OXFORDSHIRE COUNTY COUNCIL'S RESPONSE TO CONSULTATION ON THE FOLLOWING DEVELOPMENT PROPOSAL

Application no: 22/02068/REM

Proposal: Reserved Matters to 14/01932/OUT: Parcels 1 and 3 for 240 dwellings - appearance, landscaping, layout and scale

Location: OS Parcel 7400 Adjoining And South Of, Salt Way, Bodicote

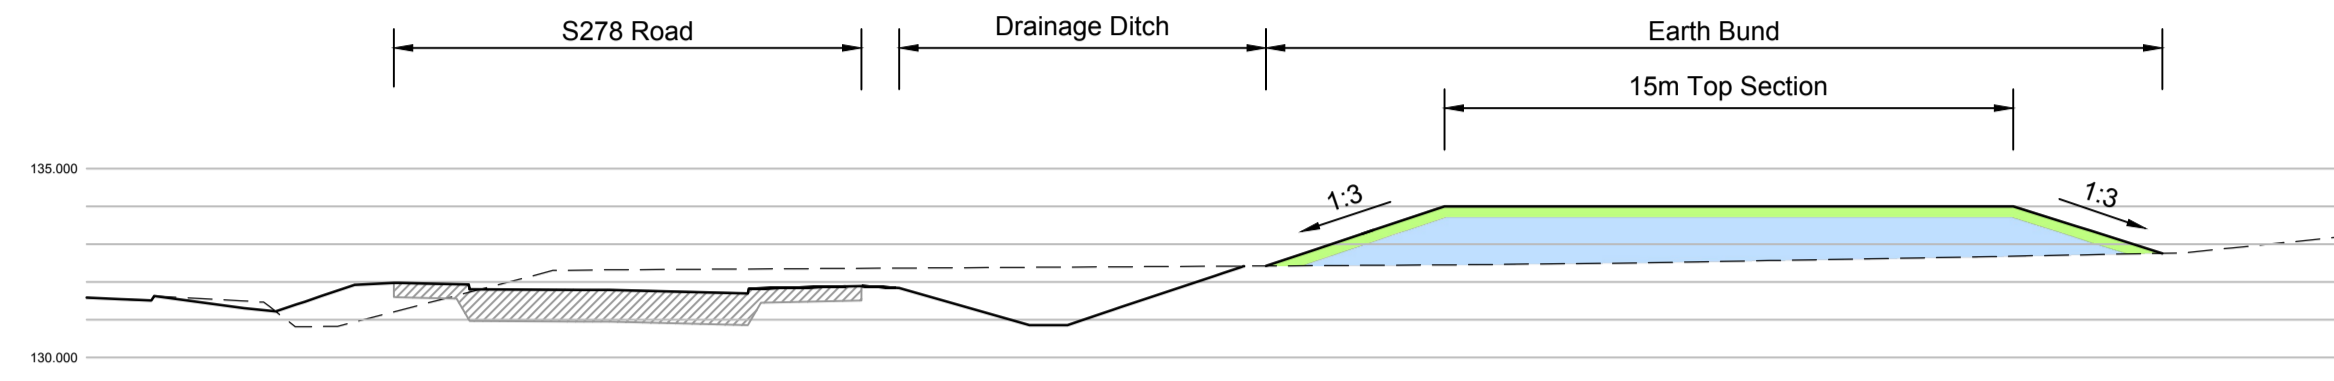
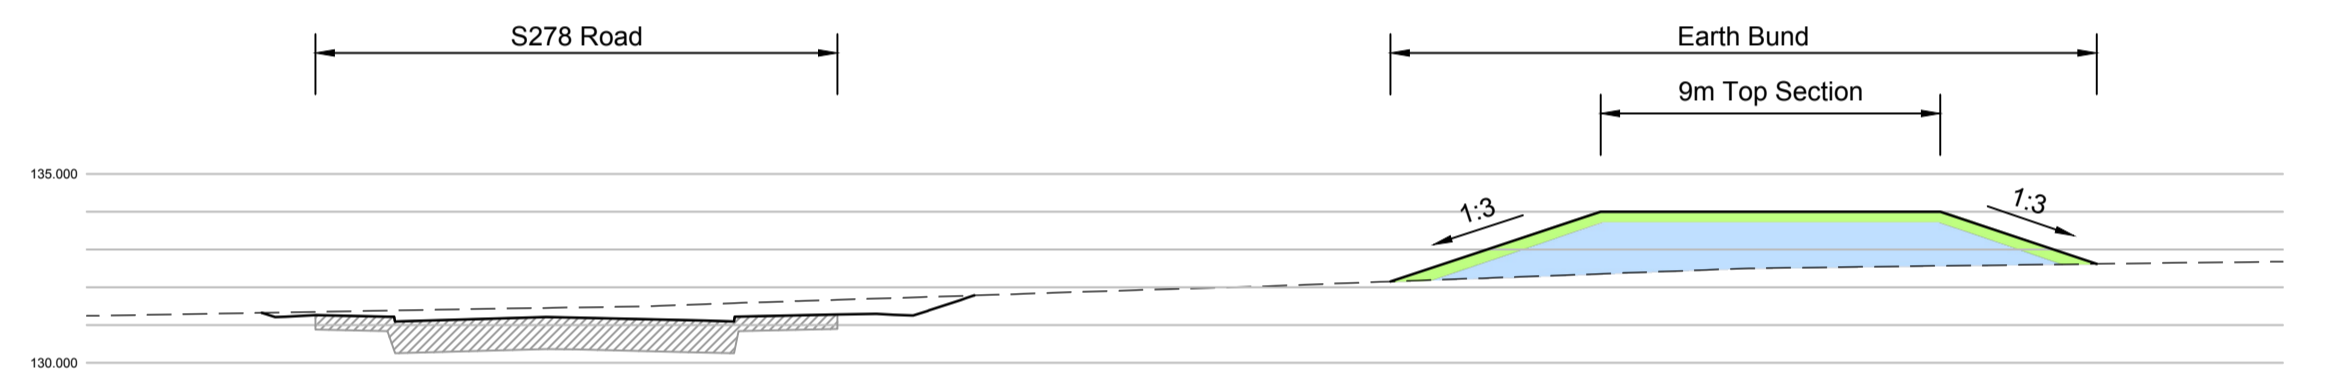
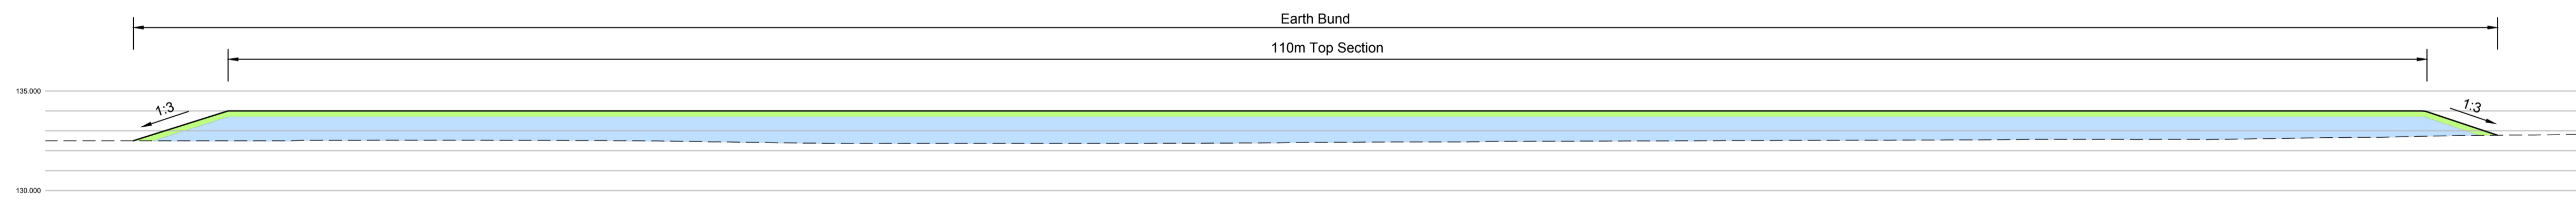
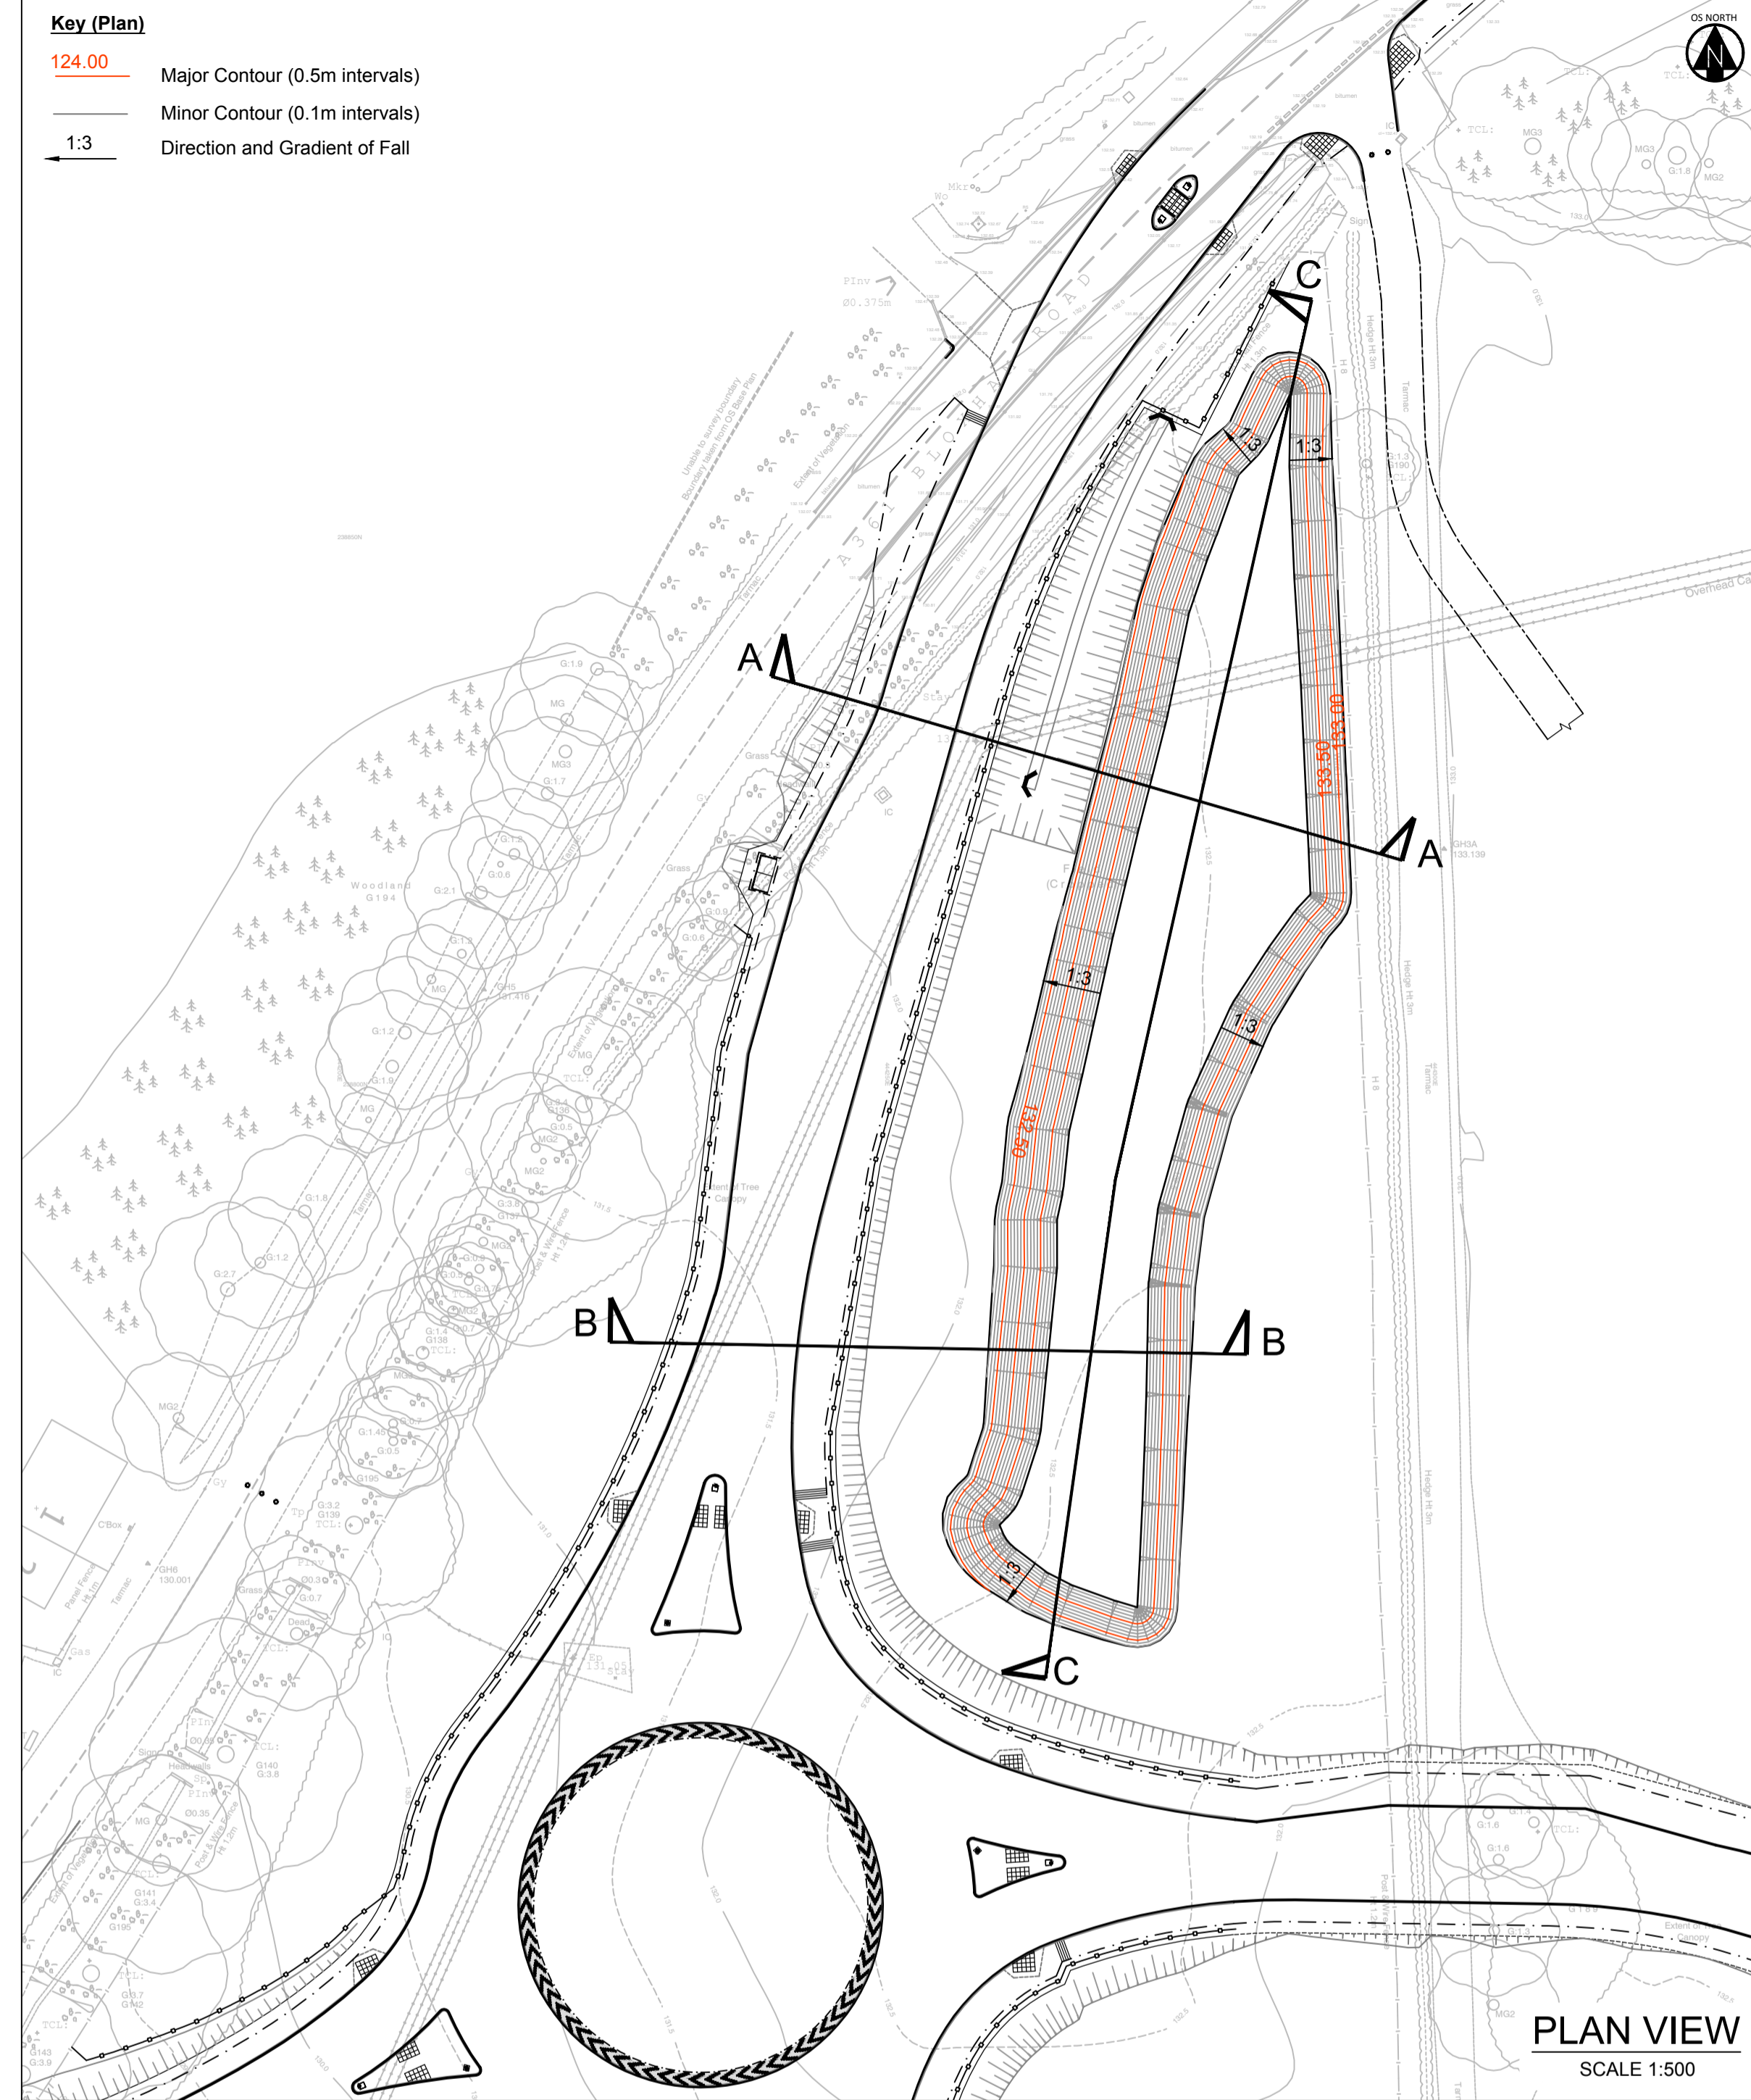
A long section was requested in the County's Transport Schedule of 15 August. This has not yet been provided and will be required to ensure compliance with the Equalities Act 2010. This must include details of the vertical alignment to determine appropriate carriageway and footway gradients. They will need to be DDA compliant i.e. maximum 1:21 or 5%. **Reason for objection.**
